Vincentia District Town Centre, Stage 1 Modification 8

Timber Screening and Landscaping Amendments
State Significant Development Modification Assessment
(MP 06_0025 MOD 8)

December 2020

drawing title
OPTION 01_VINCENTIA
DISTRICT TOWN CENTRE MOD
8 DESIGN RESPONSE

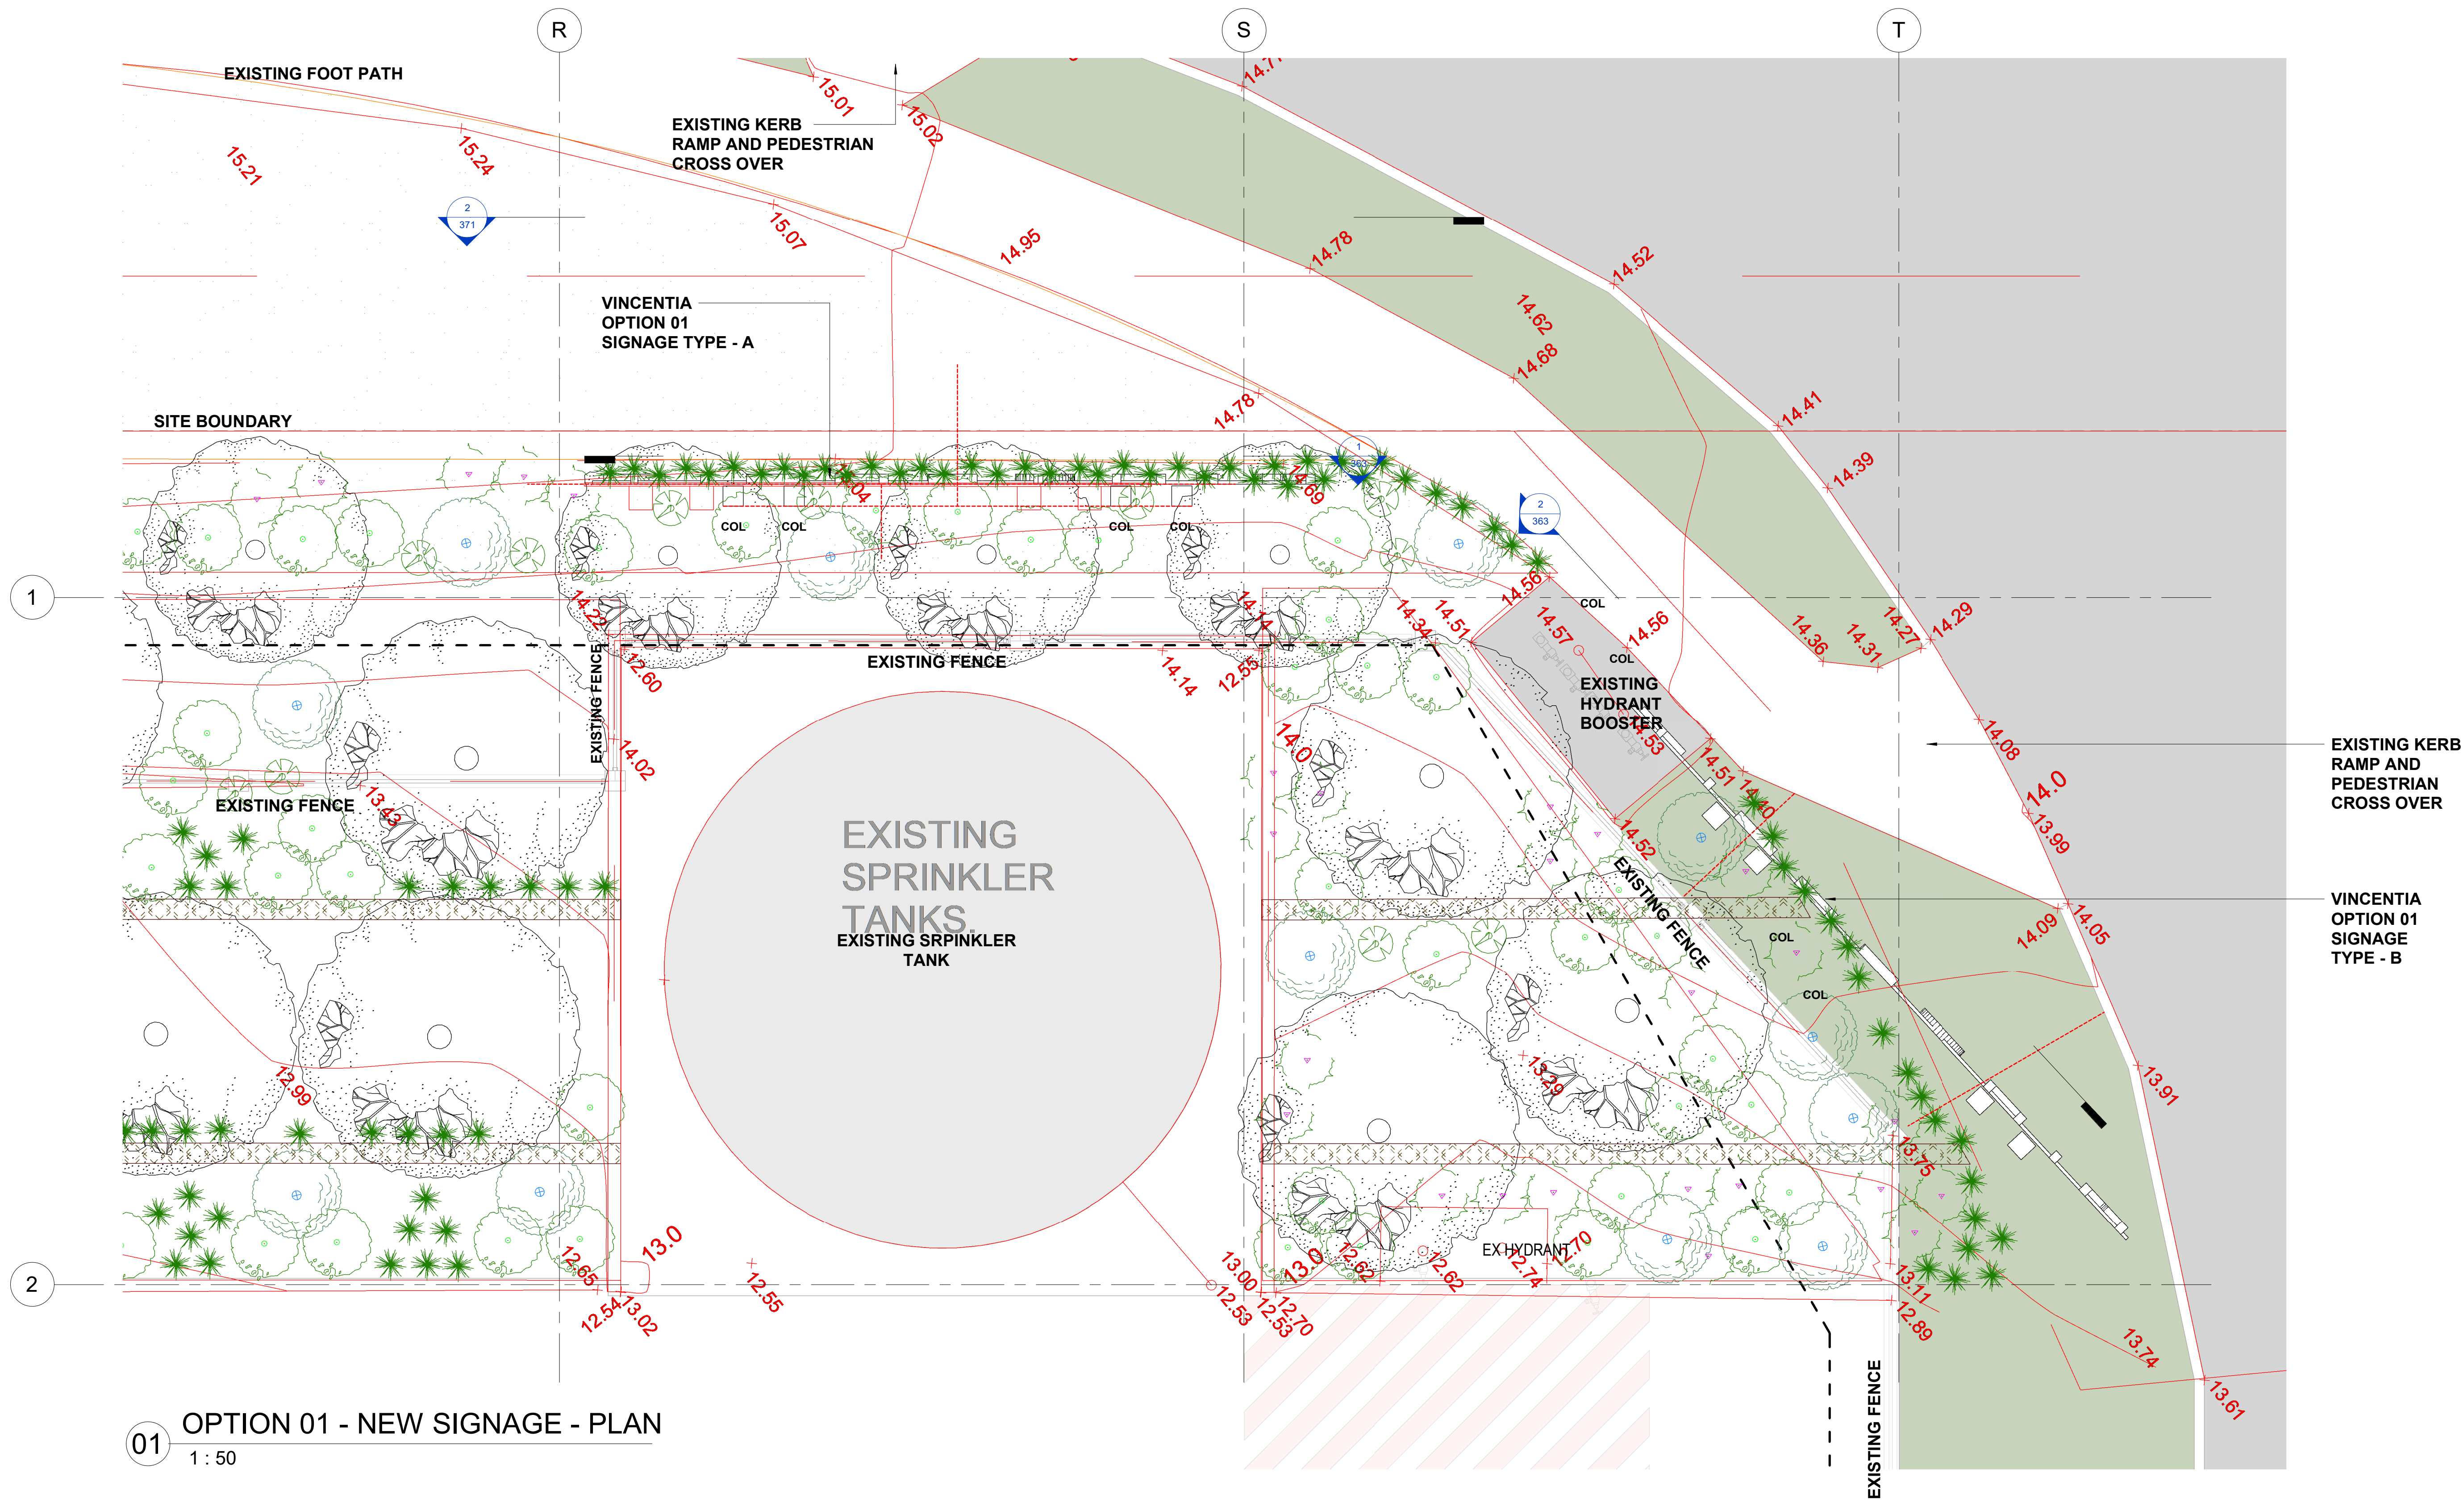
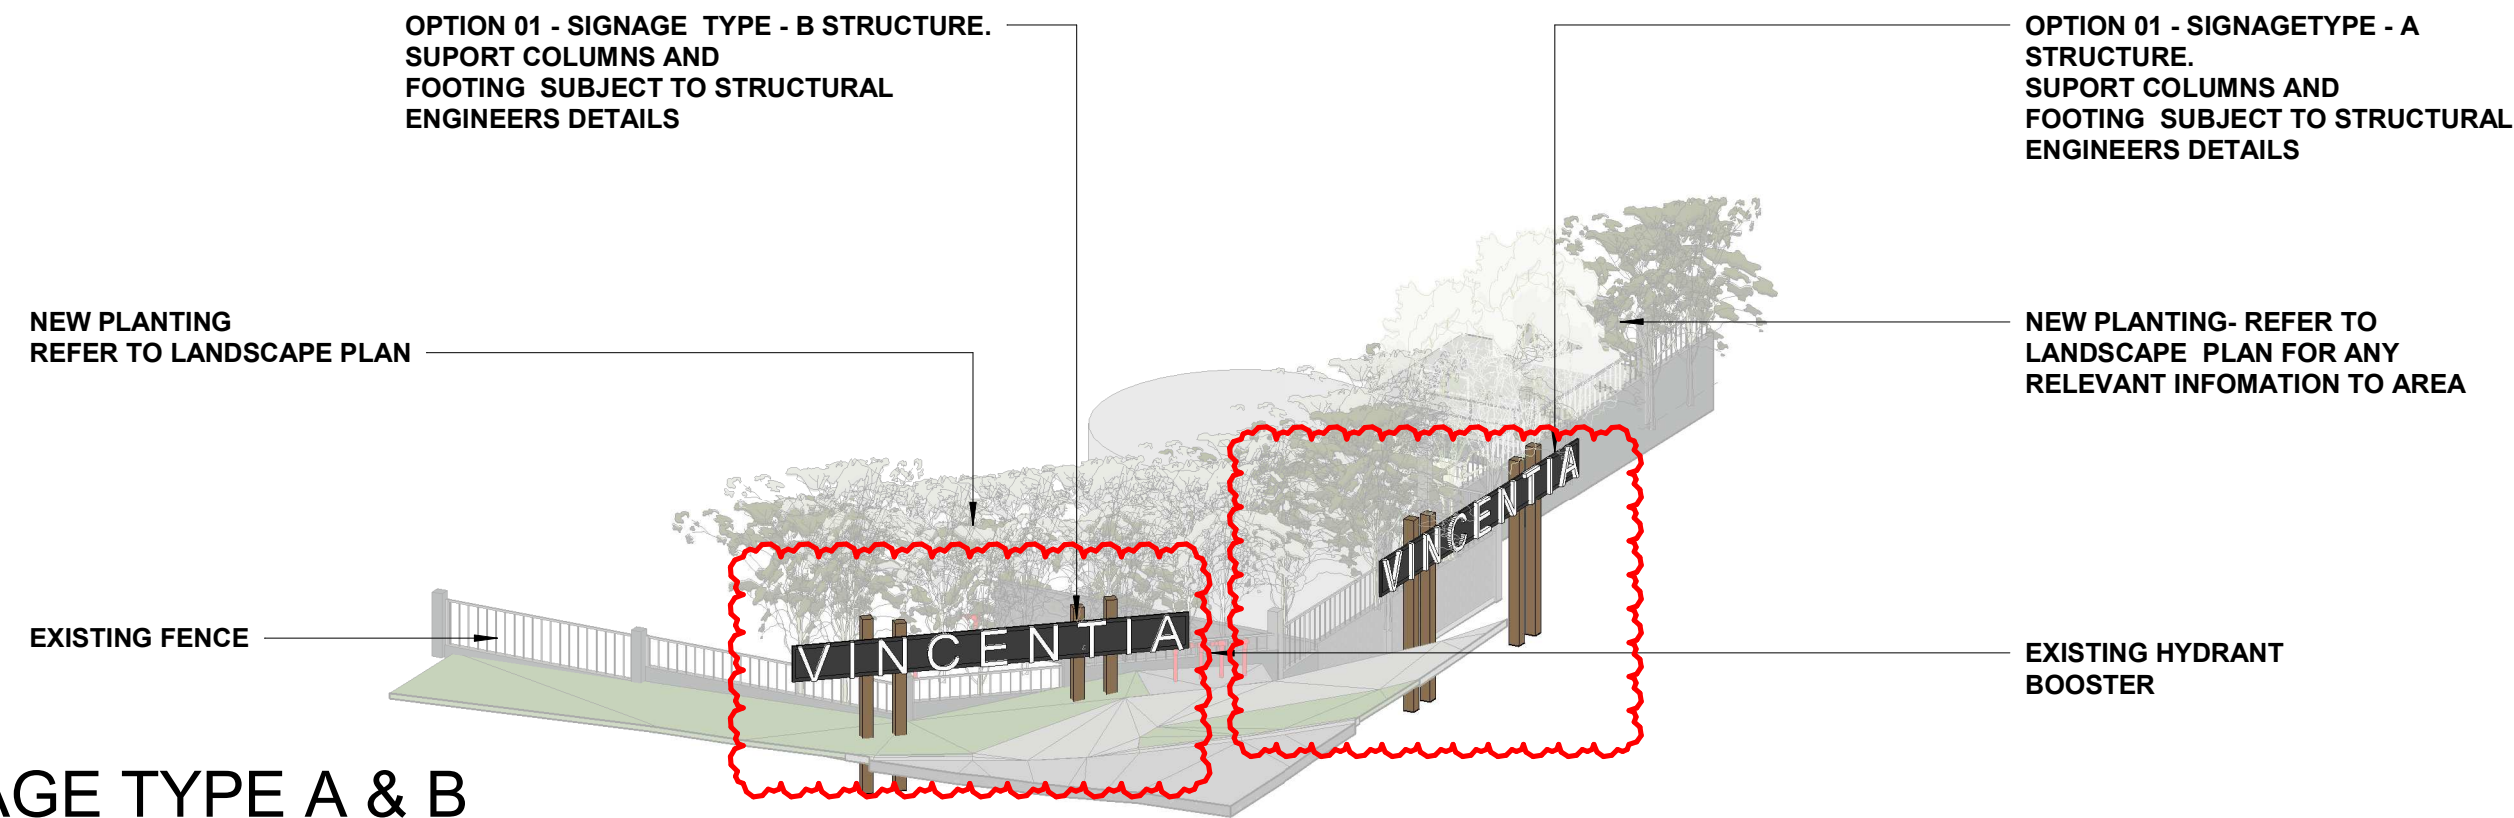
Council initially objected to the proposal and provided the following comments regarding the proposed signage:

- The signs are excessively large and constitutes visual clutter.
- The signs are at the rear of the shopping centre, rather than the entrance.
- The signs don't appear to serve a purpose other than screening.
- The signs do not fit with Council's signage strategy and have no relevance to Bayswood Estate or the larger Vincentia village.
- A preferred outcome would be increased plantings to thicken the screen and/or the provision of a decorative screen with no words.

In response to Council's submission, the proponent removed the proposed signage and amended the landscape plan. The revised landscape plan was forwarded to Council for comment and on 27 November, 2020 Council advised that it is supportive of the changes to the proposal.
